**From:** Colin King [REDACTED]  
**Sent:** 01 September 2020 22:11  
**To:** Norfolk Boreas <NorfolkBoreas@planninginspectorate.gov.uk>  
**Subject:** Norfolk Boreas Project EN10087.

Applicant's Comments on Deadline 13 Submissions (my comments).

1.11 Rep13-042.

Title:	Scenario 1 Viewpoint 2: Lodge Lane South
--------	--

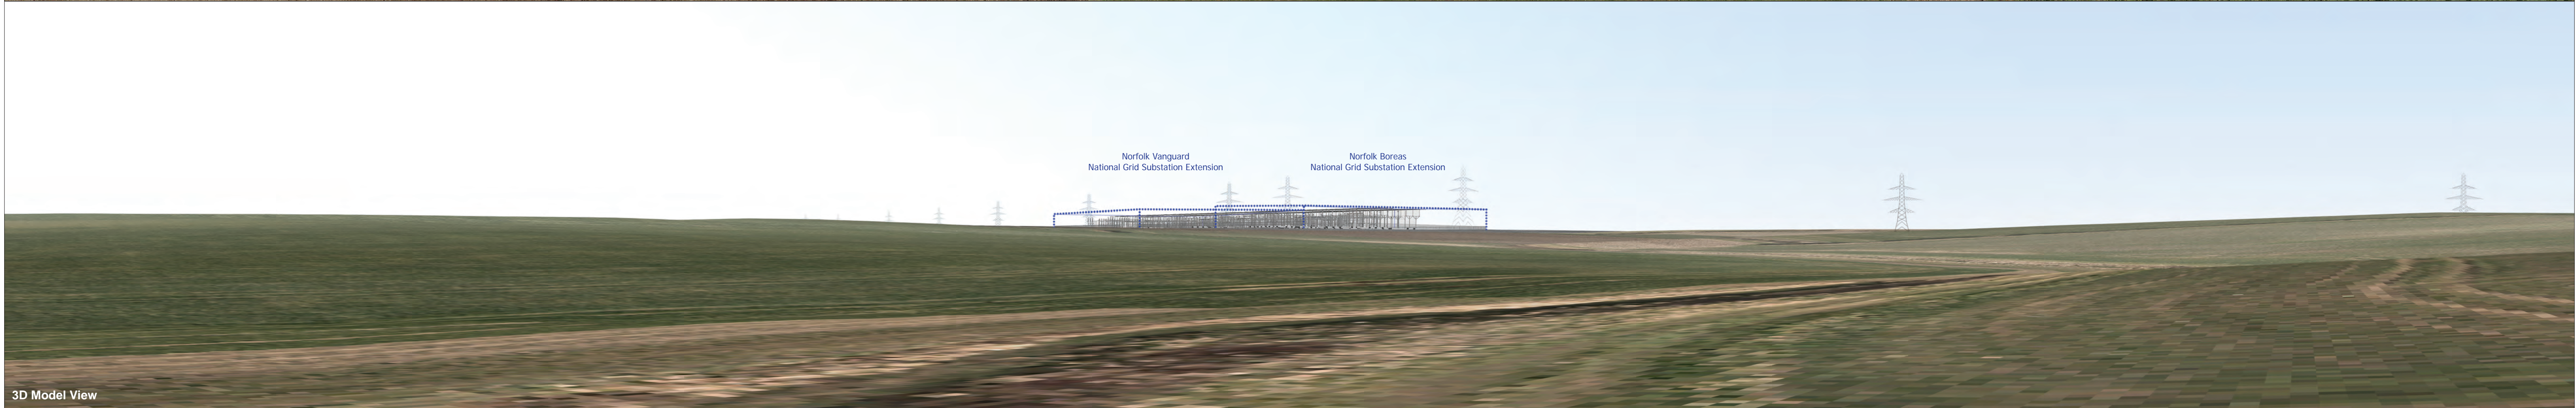
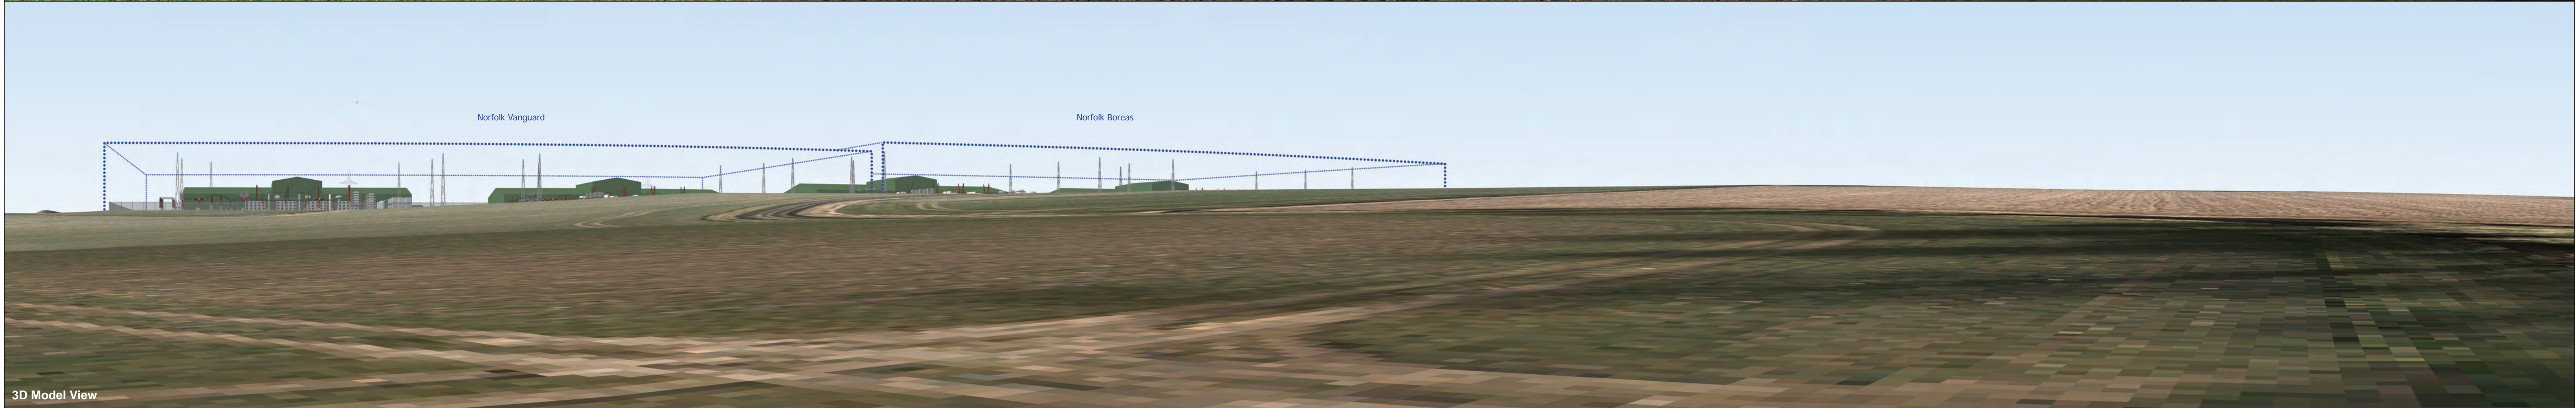
Also they state "it is not possible or appropriate to set minimum parameters" and yet they show the images of the converter halls in their words, "***A 3D model of the onshore substation has been used to give an indication of what the substation will look like and a blue dotted box represents the Rochdale envelope, within which the substation elements can move. By showing the blue Rochdale envelope alone, we may overestimate the extents to which the development could be visible. By showing just the substation model alone, we may underestimate visibility. Hence, the use of both techniques in the visualisations.***" (from comments on relevant representations page 153, table 24 no4,)

This suggests the substation model (converter halls) in the visualisations are shown as a possible underestimation, and yet they state "it is not possible or appropriate to set minimum parameters," and it should be shown as a worst case assumption.

This I believe fails to show the required worst case assumption, as it is not obvious that the blue dotted box is anything more than the extent of footprint dimensions.

Viewpoint 2. Lodge Lane South

specifically give an impression that the converter halls are built out of the site footprint.

Figure: 29.37a	Drawing No: PB5640-005-029-037				
Revision:	Date:	Drawn:	Checked:	Size:	Scale:
01	14/02/2019	LA	JP	A3	Multiple
02	21/02/2019	LA	JP	A3	Multiple

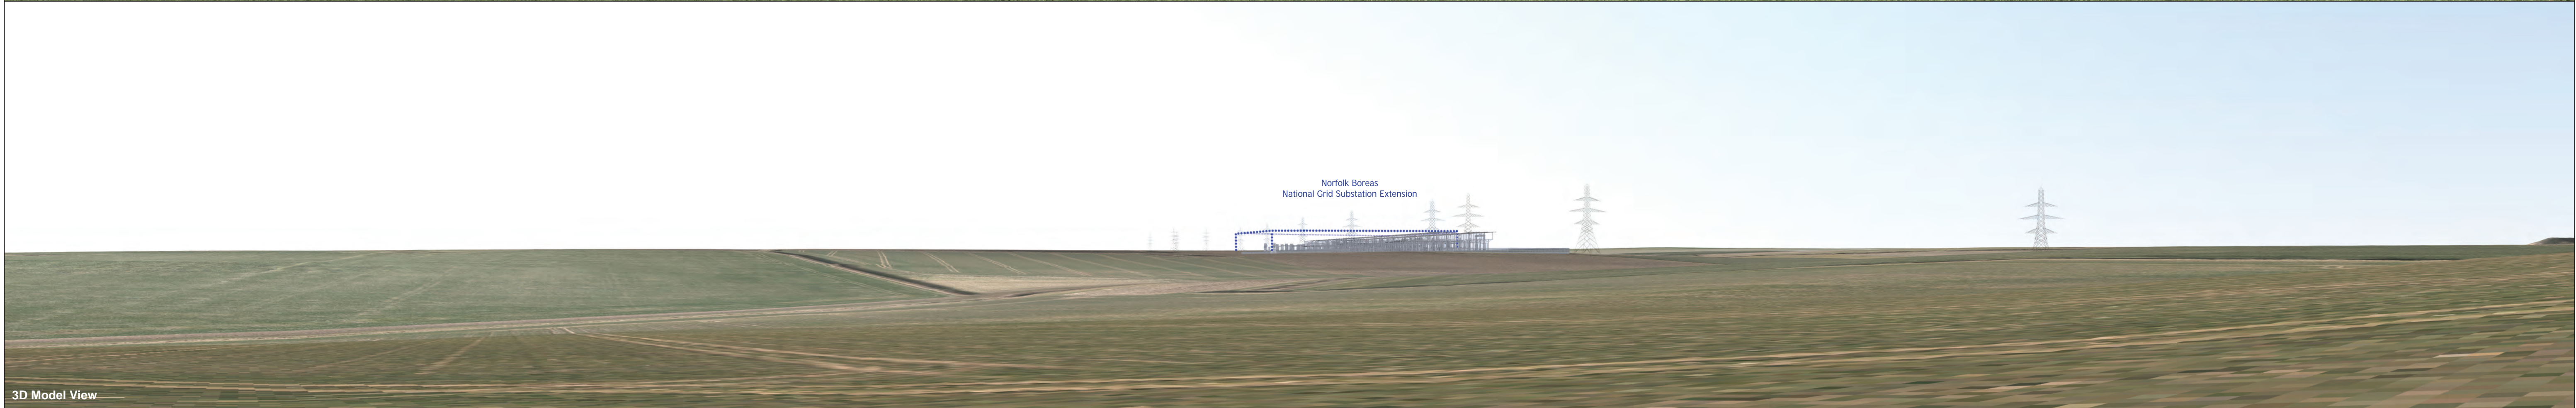
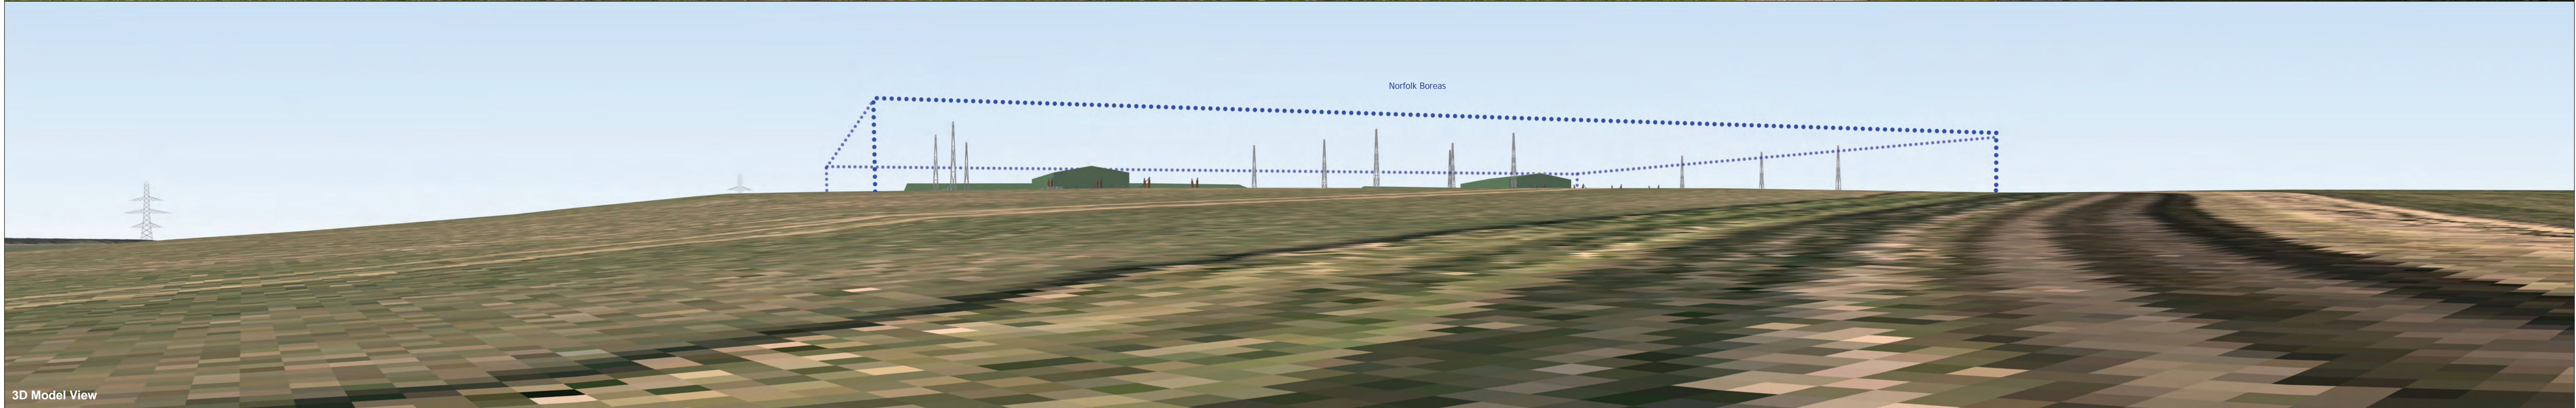
Viewpoint 3. Lodge Lane North
